EL PASO COUNTY STORMWATER MANAGEMENT PLAN CHECKLIST

EPC Project Number: PPR-21-046

Revised: July 2019

EROSION CONTROL DETAILS  
7520 FALCON MARKET PLACE  
PEYTON, CO 80831

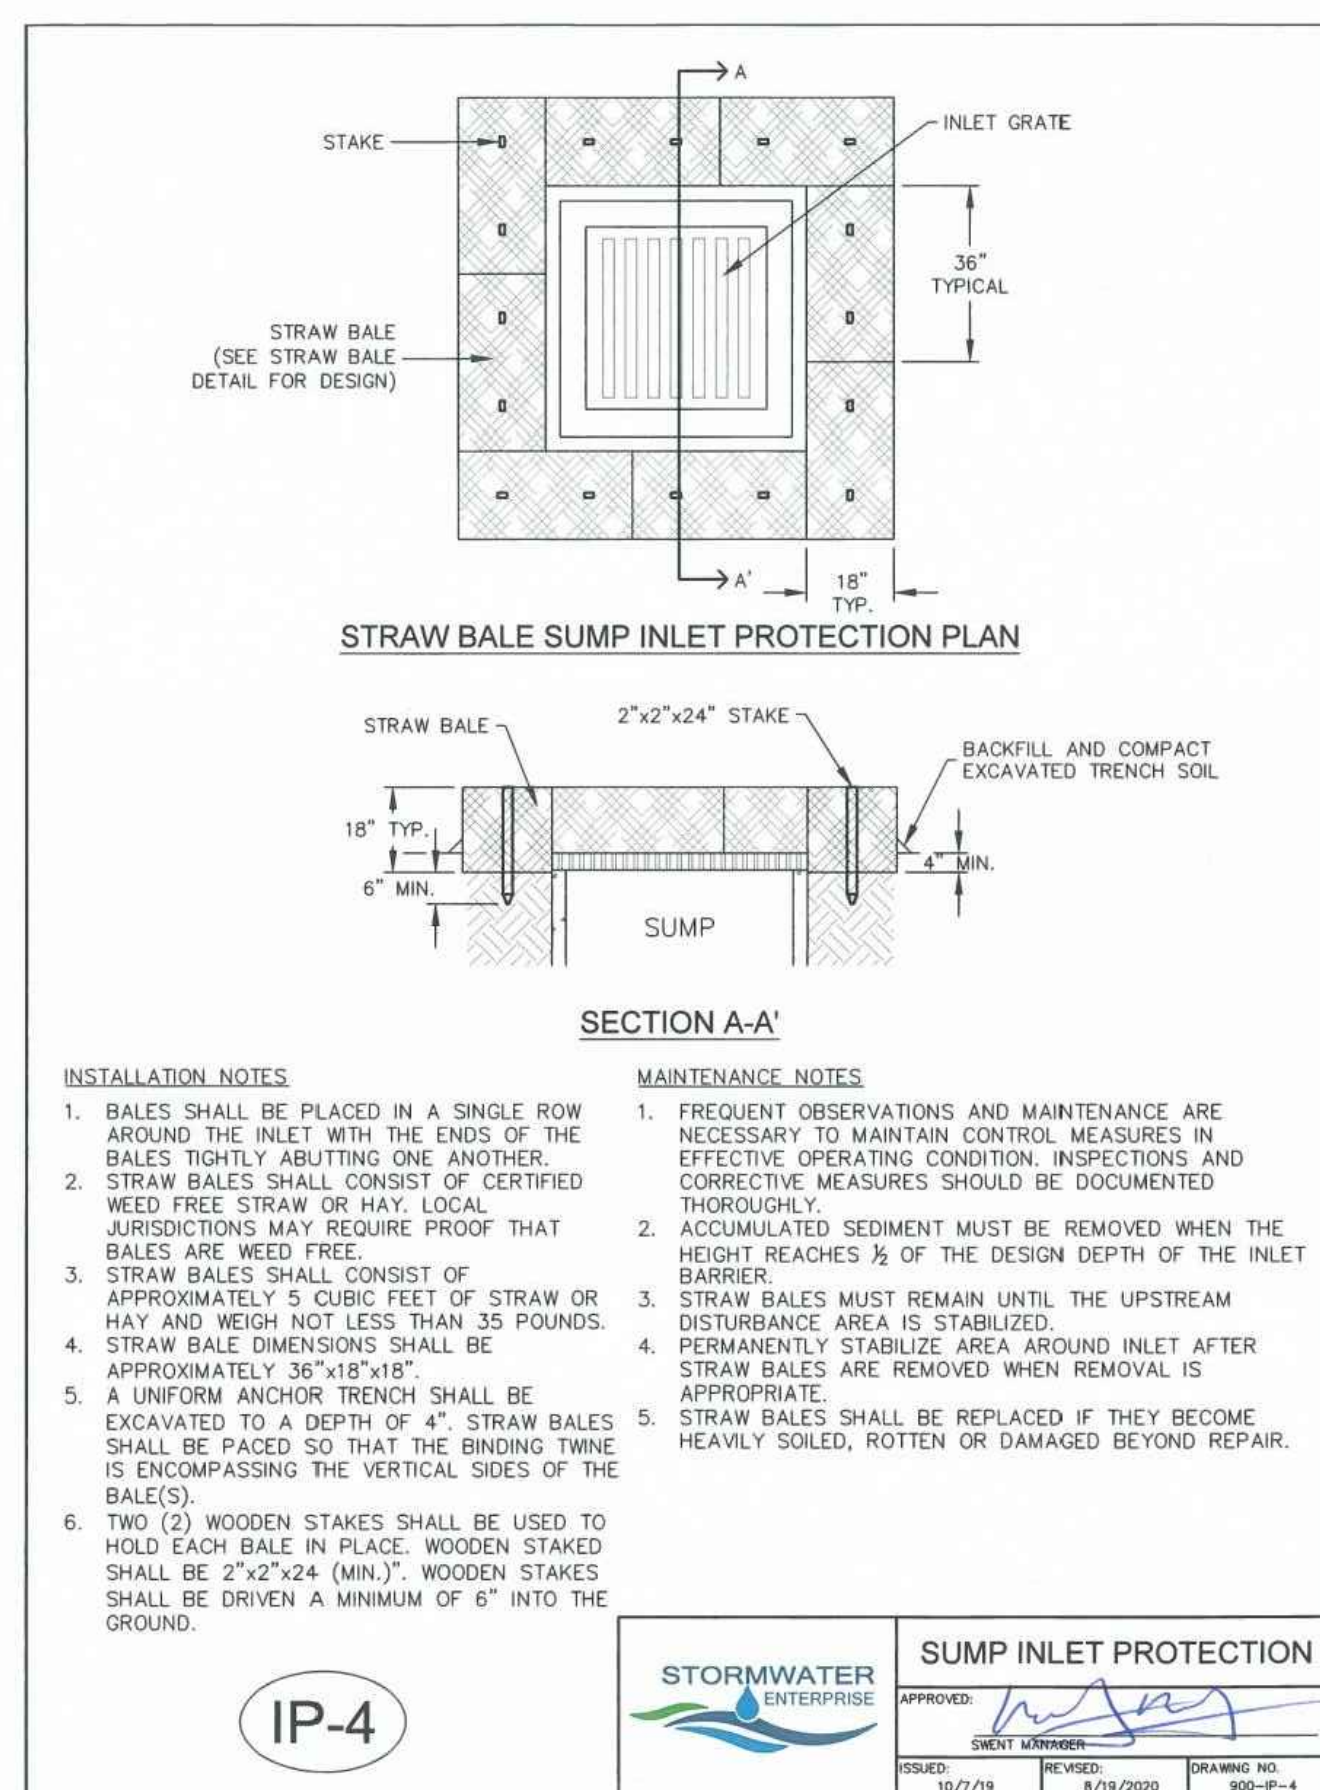
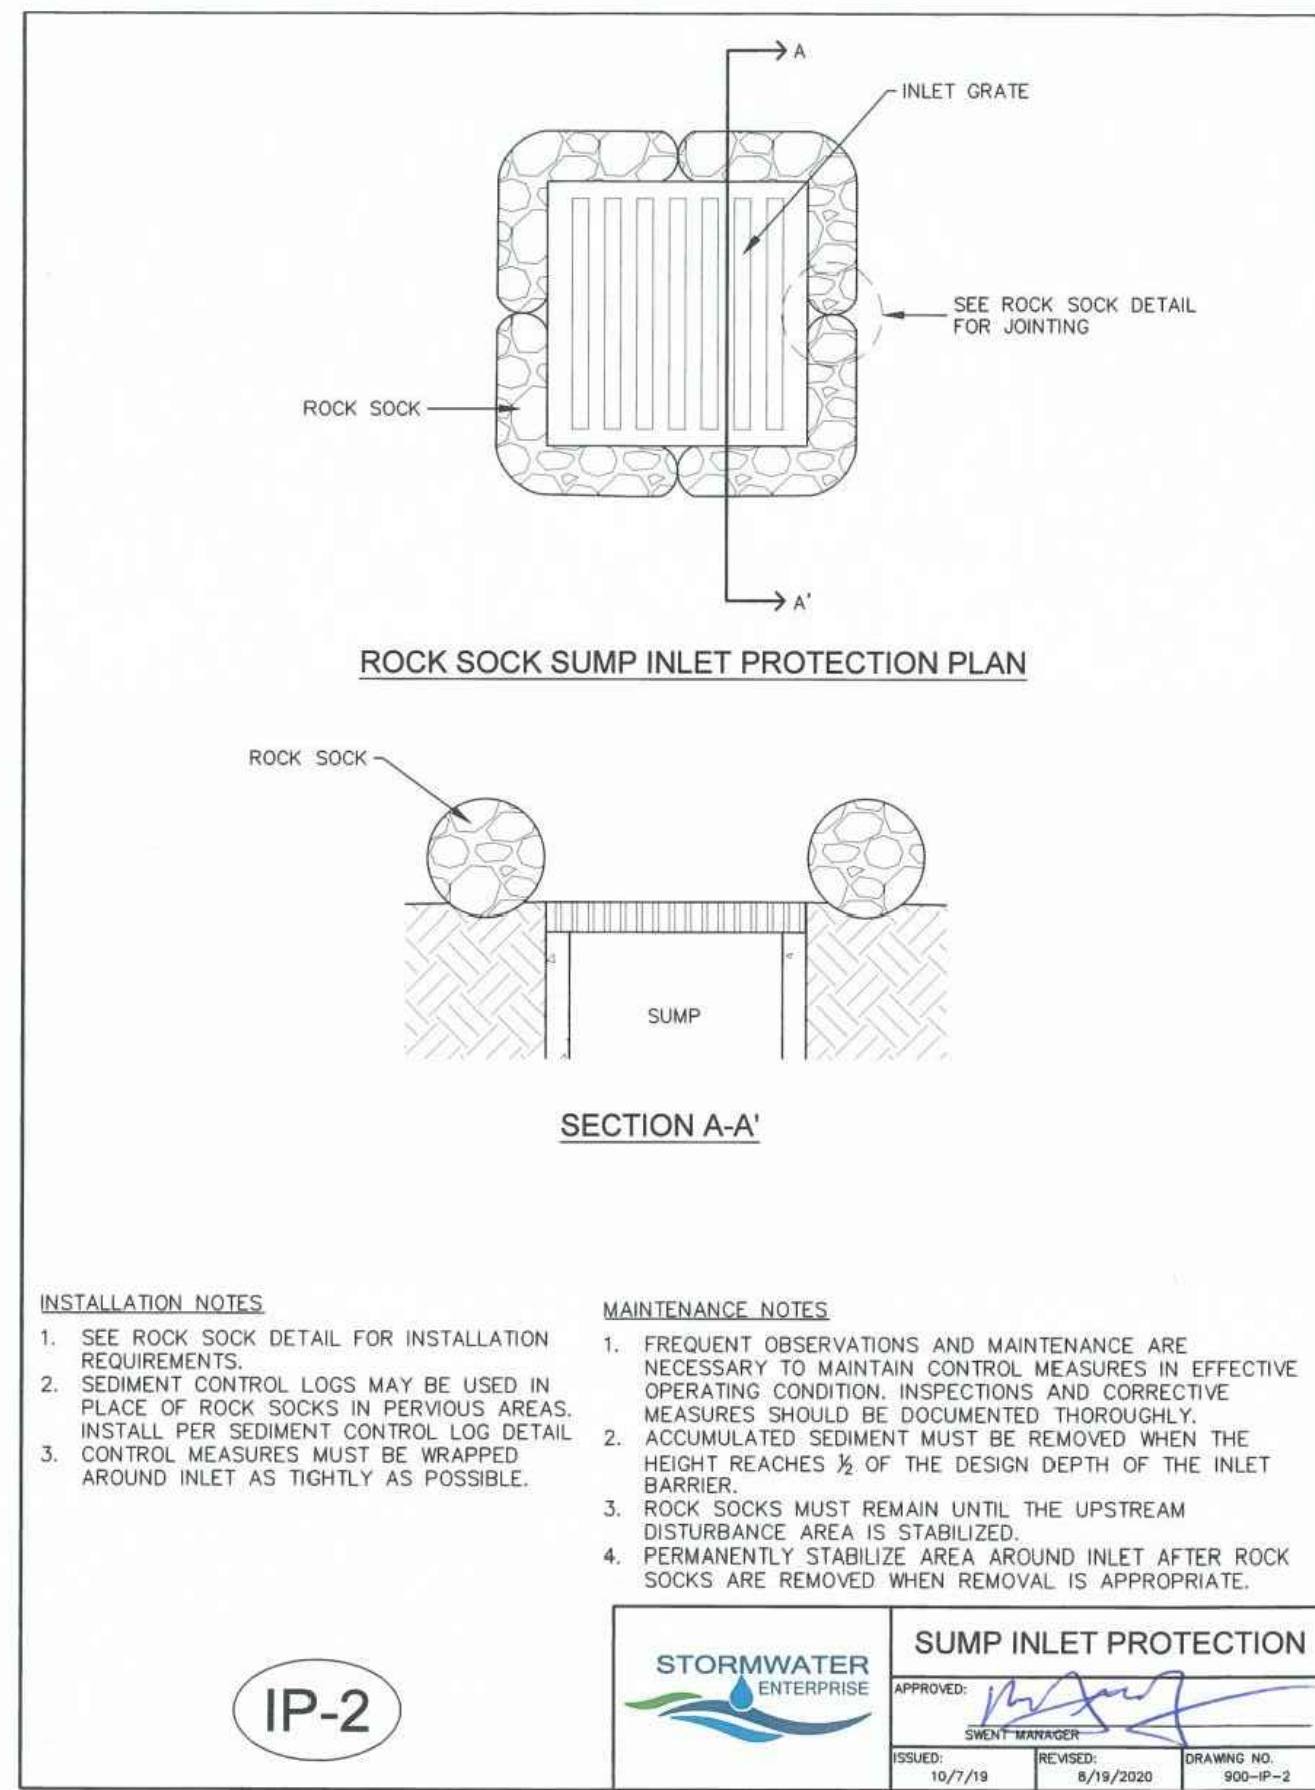
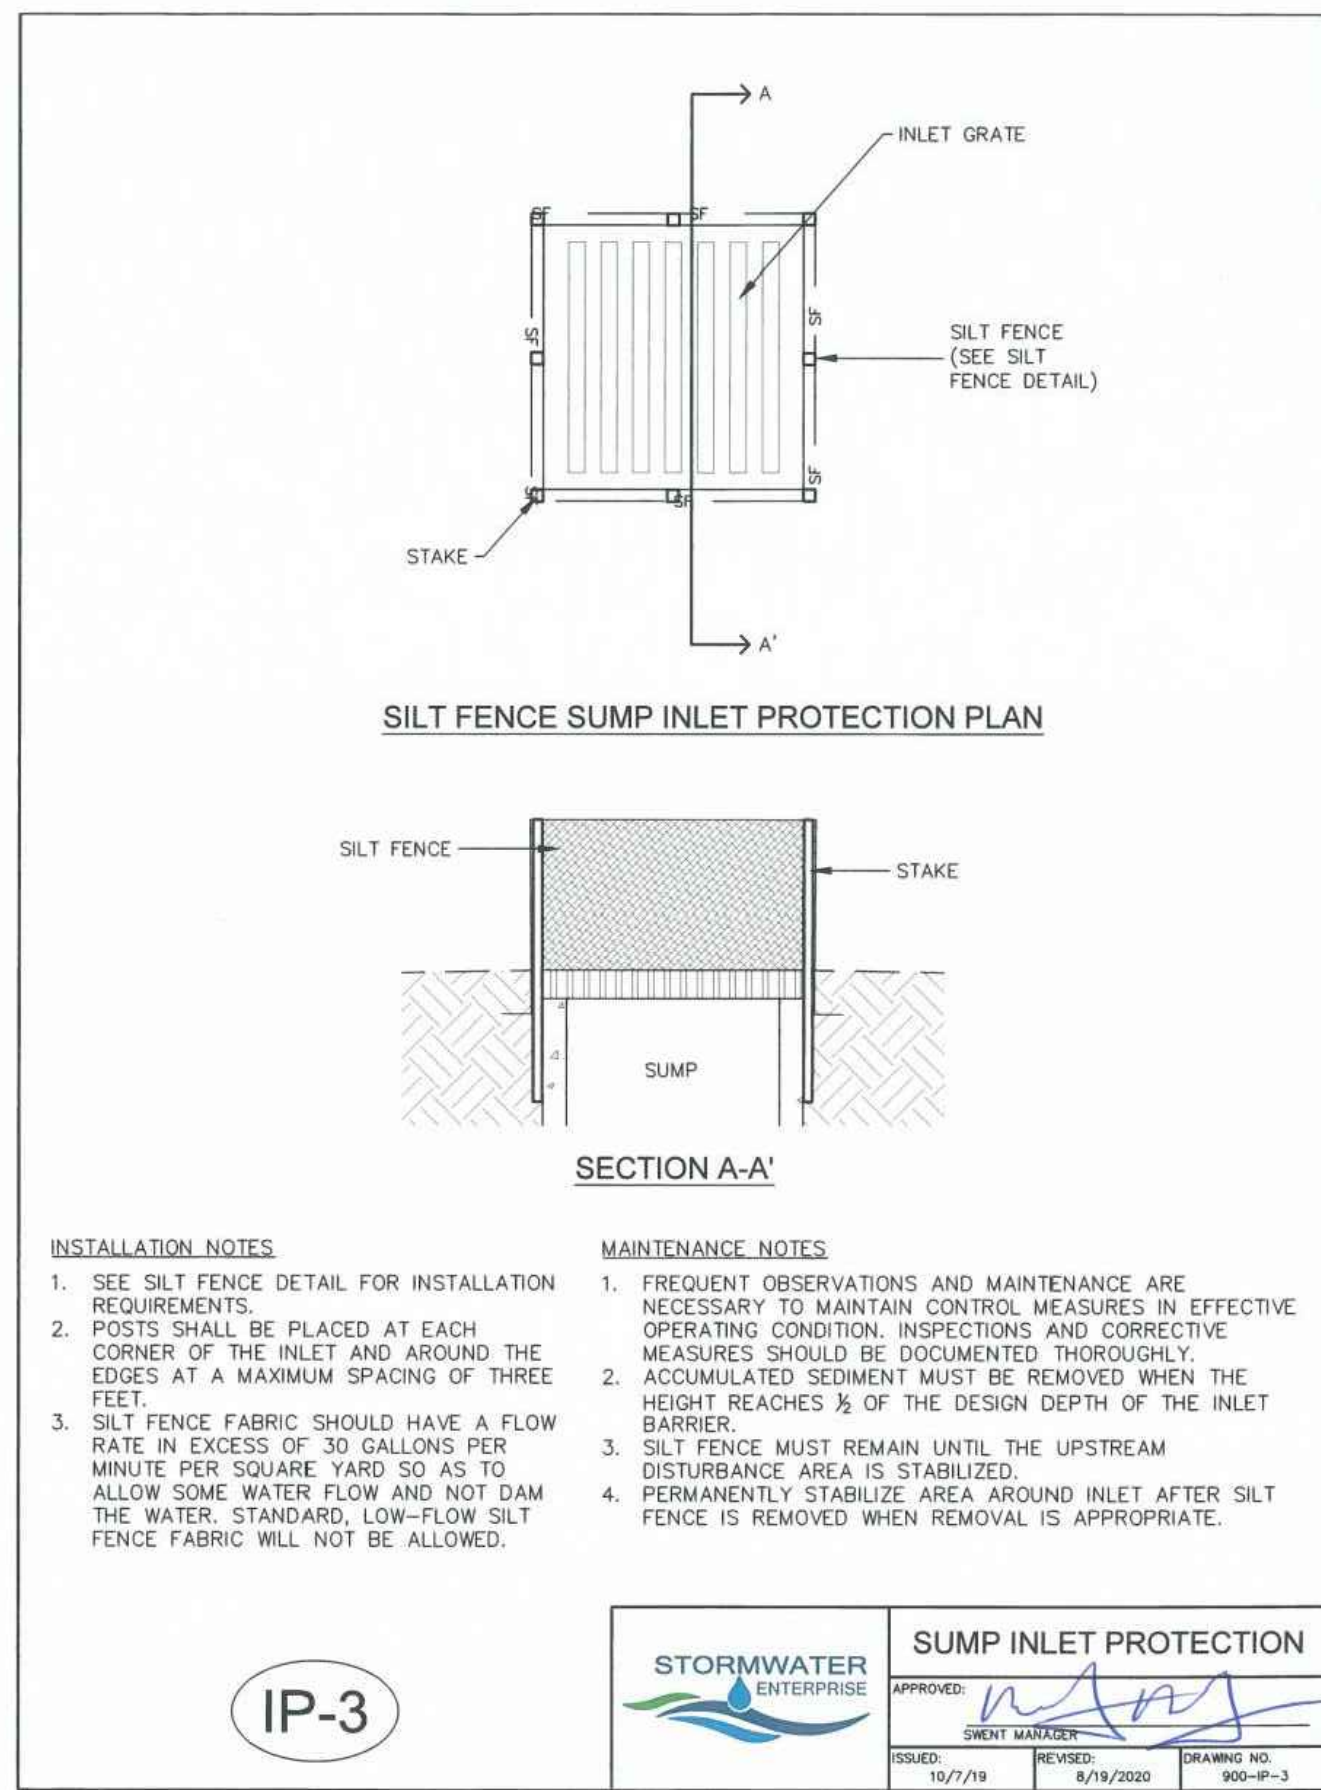
20	Technical drawing details for all control measure installation and maintenance; custom or other jurisdiction's details used must meet or exceed EPC standards		X
21	Procedure describing how the SWMP is to be revised		X
22	Description of Final Stabilization and Long-term Stormwater Quality (describe nonstructural and structural measures to control SW pollutants after construction operations have been completed, including detention, water quality control measure etc.)		X
23	Specification that final vegetative cover density is to be 70% of pre-disturbed levels		✓
24	Outline of permit holder inspection procedures to install, maintain, and effectively operate control measures to manage erosion and sediment		✓
25	Record keeping procedures identified to include signature on inspection logs and location of SWMP records on-site		X
26	If this project relies on control measures owned or operated by another entity, a documented agreement must be included in the SWMP that identifies location, installation and design specifications, and maintenance requirements and responsibility of the control measure(s)		✓
